OXFORDSHIRE COUNTY COUNCIL'S RESPONSE TO CONSULTATION ON THE FOLLOWING DEVELOPMENT PROPOSAL

Application no: 23/00170/REM

Proposal: Reserved Matters Application pursuant to outline planning permission 14/02121/OUT for Phase 1A (infrastructure comprising two junctions to provide vehicular and pedestrian access into the site from Middleton Stoney Road and two initial sections of internal road) along with the partial compliance of conditions 12 (Building for Life 12), 16 (means of vehicular access), 17 (means of pedestrian/cycle links) and 19 (detailed surface water drainage scheme) for Phase 1A.

Location: Proposed Himley Village North West Bicester, Middleton Stoney Road, Bicester

TITLE MIDDLETON STONEY ROAD, MAIN SPINE ROAD JUNCTION. GENERAL ARRANGEMENT SHEET 1	
HYDROCK PROJECT NO. C-27141-C	SCALE @ A2 1 : 500
STATUS DESCRIPTION INFORMATION	STATUS S2
DRAWING NO. (PROJECT CODE-ORIGINATOR-ZONE-LEVEL-TYPE-ROLE-NUMBER) 27141-HYD-XX-XX-DR-D-0001	REVISION P02

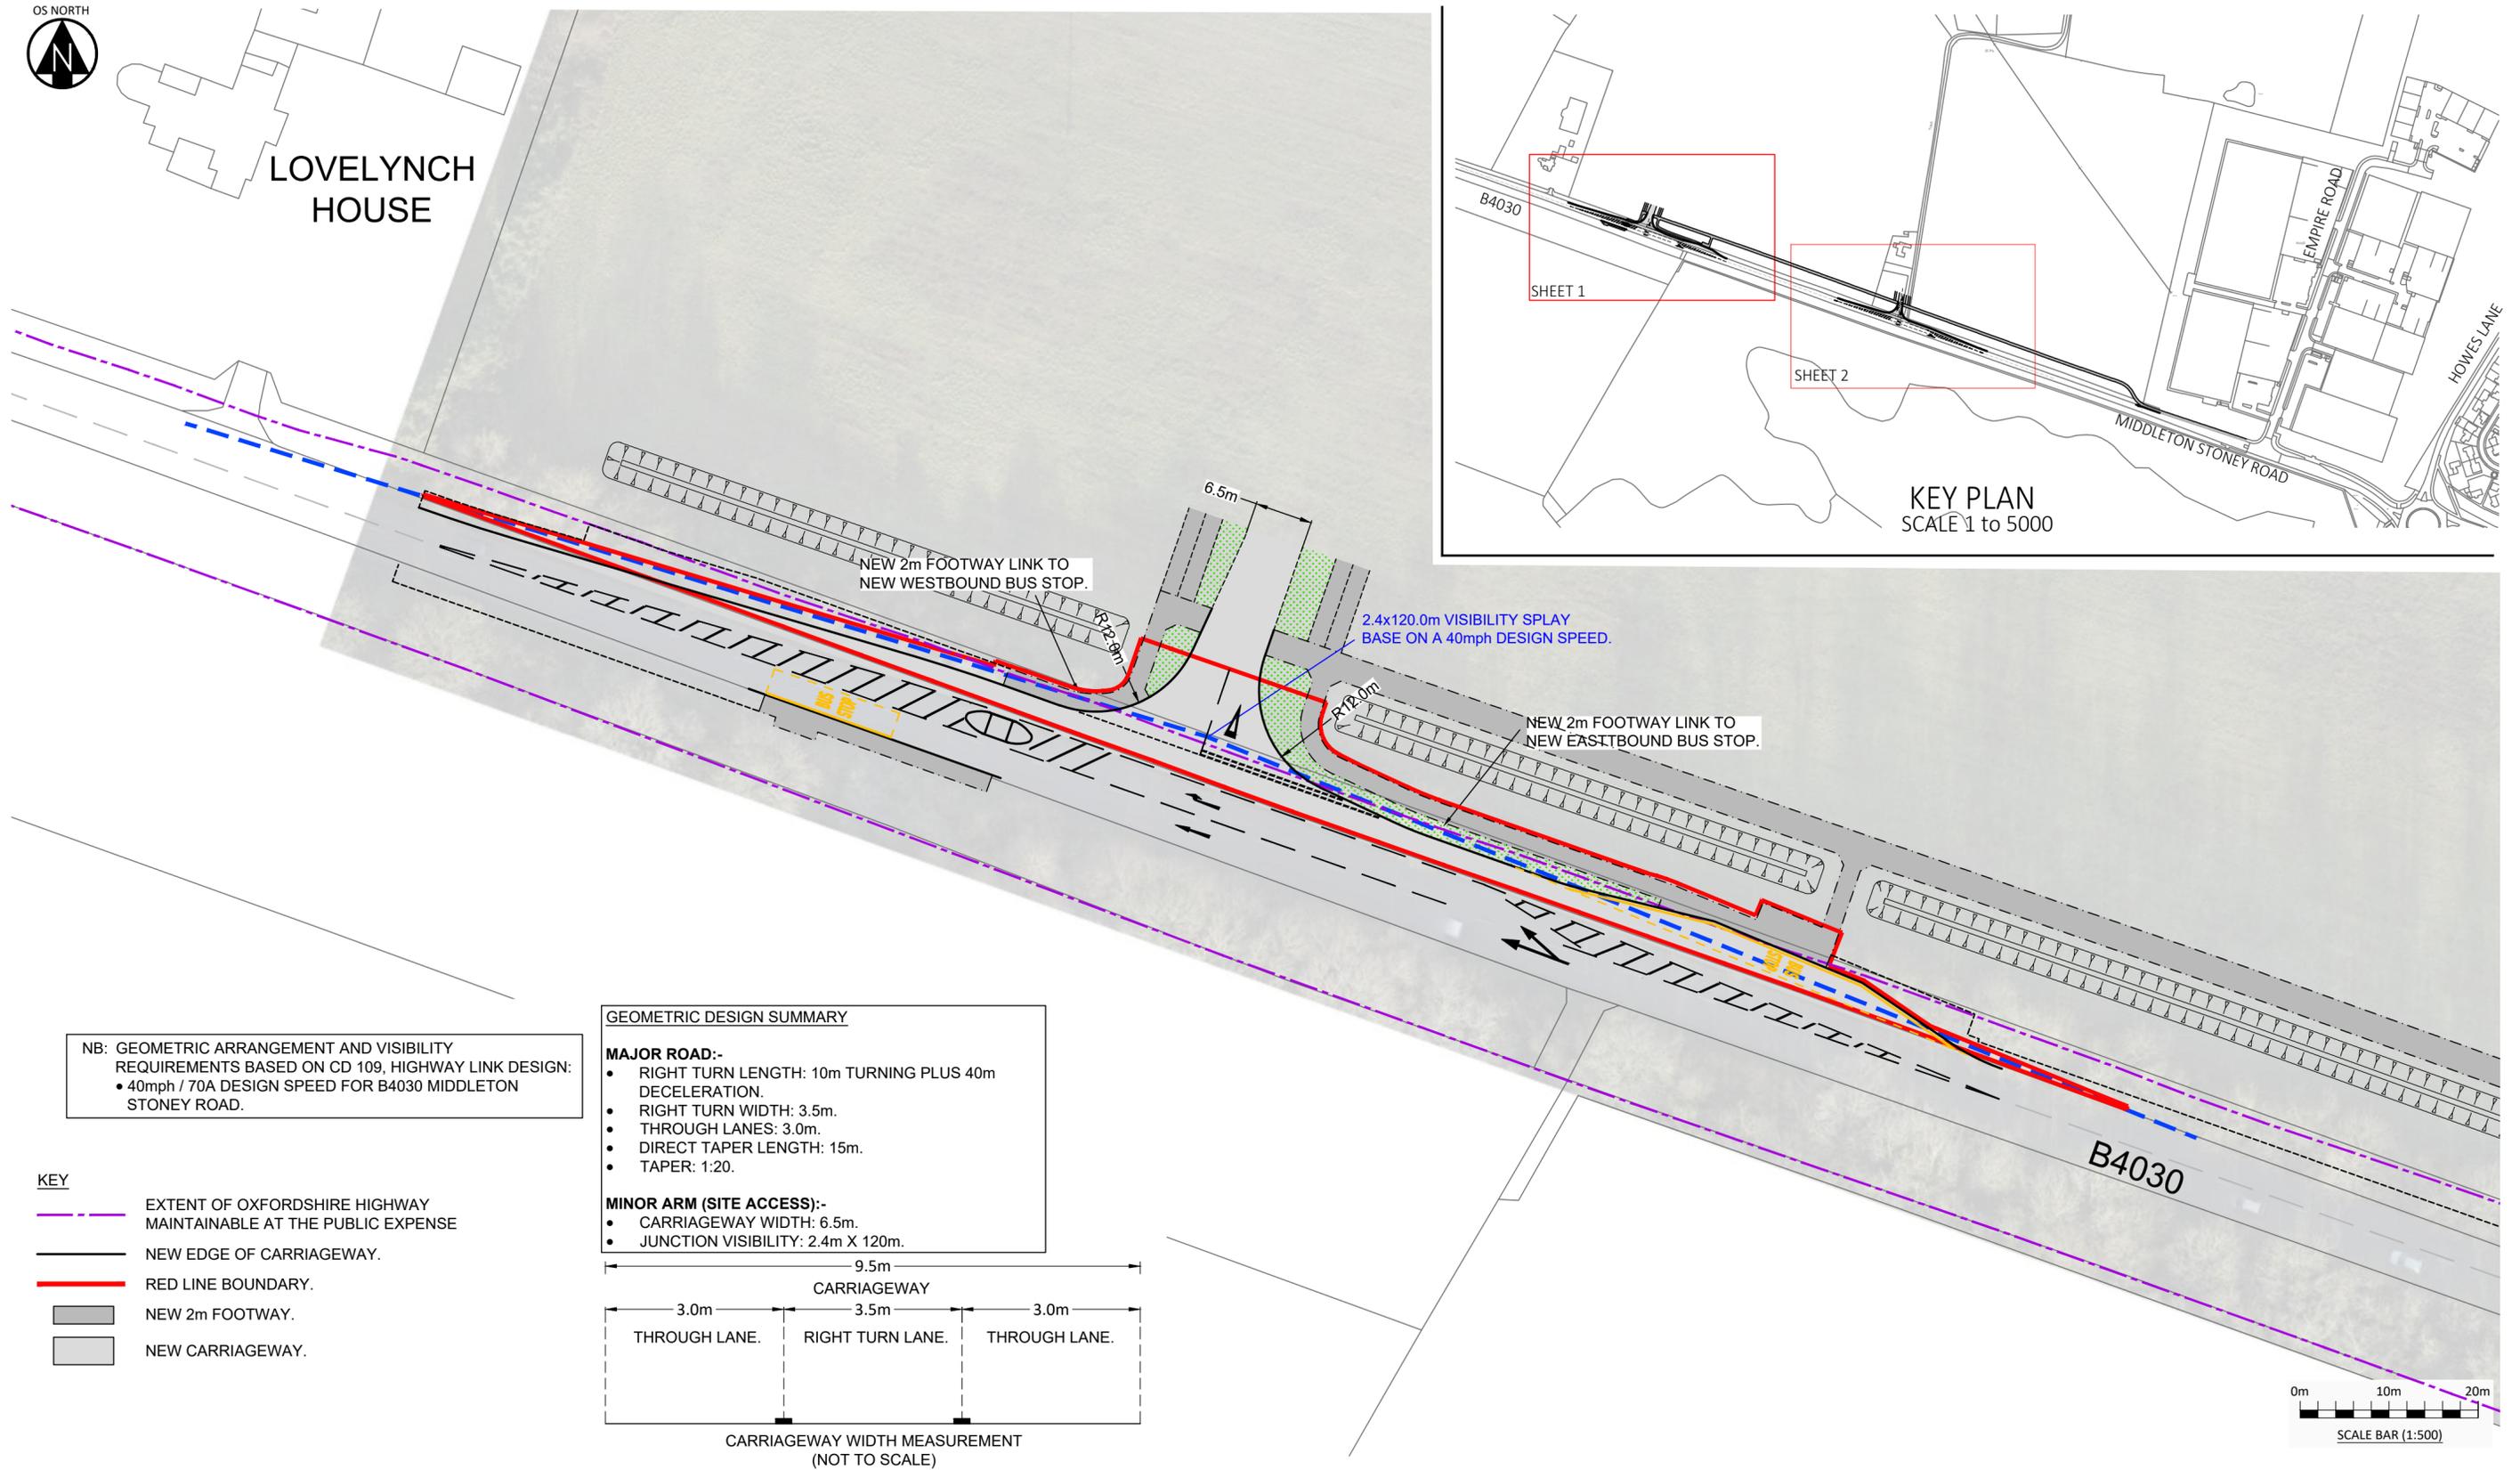
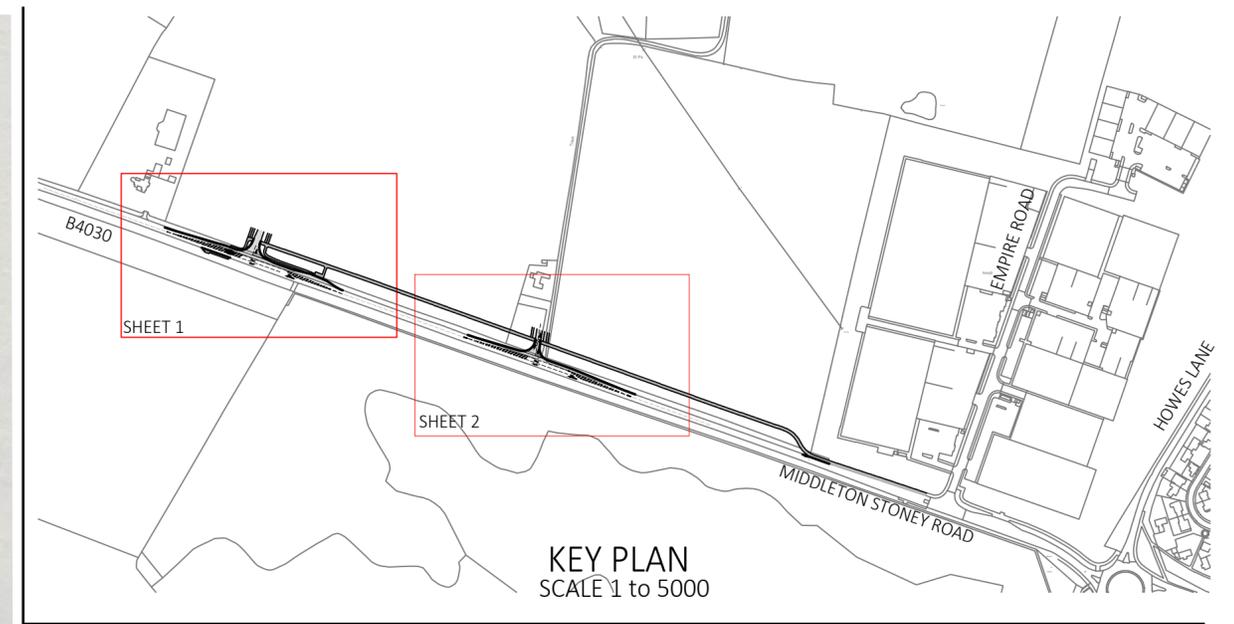
The red line area has been amended (on drg. 0001 Rev. P02) to incorporate a revised footway arrangement to the two bus stops. This tallies with the adjusted footway and cycle lane provision, as separately agreed, along the Spine Road, as shown on Rev. P03 of the Pedestrian & Cycle Link (Permanent) GA drg. no. 0006.

Details of the access will be finalised during the technical approval process of the Section 278 application.

TITLE  
MIDDLETON STONEY ROAD,  
SECONDARY ROAD JUNCTION.  
GENERAL ARRANGEMENT  
SHEET 2

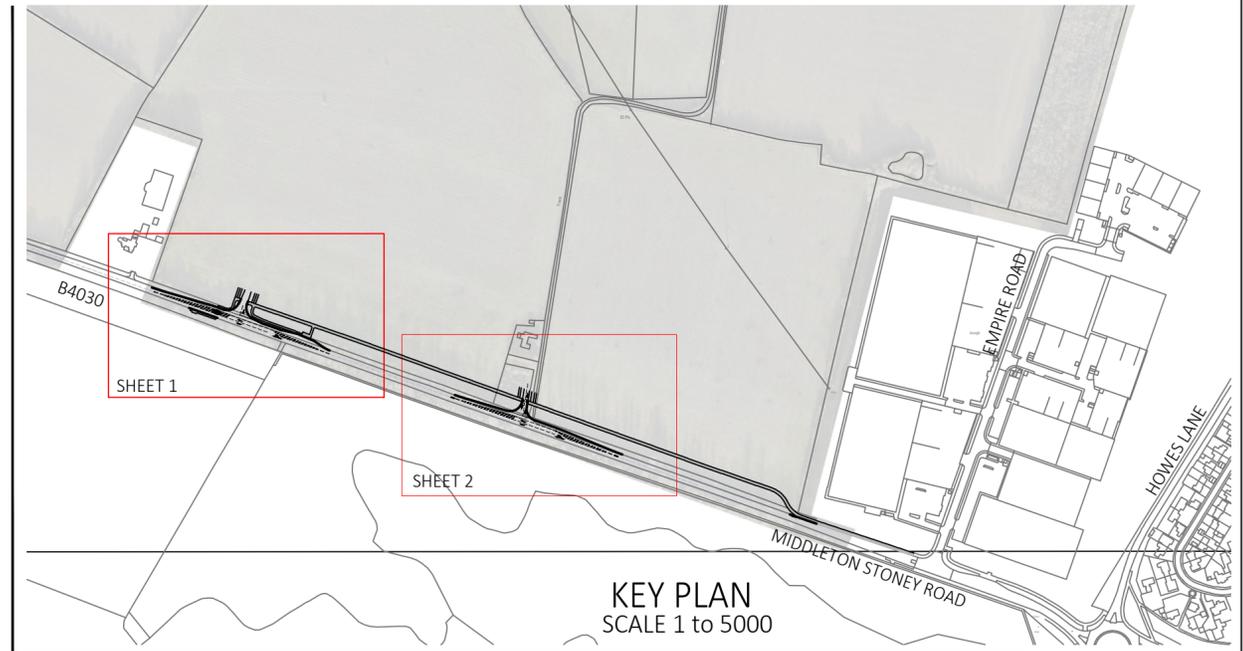
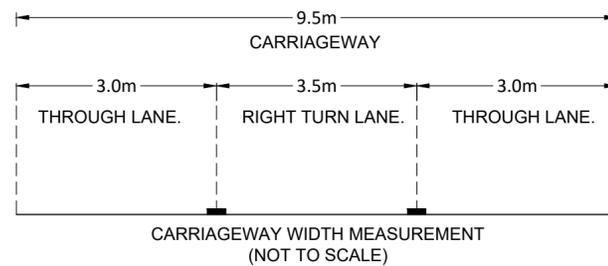
The red line area is similar to that shown on the previous revision. Pedestrian and cycle facilities, as agreed, outside of the area have been added for clarity.

The previous reason for objection, that the 5.5m width of the secondary road is too narrow for a bus service, has been addressed in separate correspondence. Adequate public transport provision will be achieved for an interim period from the service on Middleton Stoney Road prior to buses entering the site via the primary access road and the adjoining Axis J9 development. Therefore, buses will not route via the secondary road, and the 5.5m width is acceptable.

Details of the access will be finalised during the technical approval process of the Section 278 application.
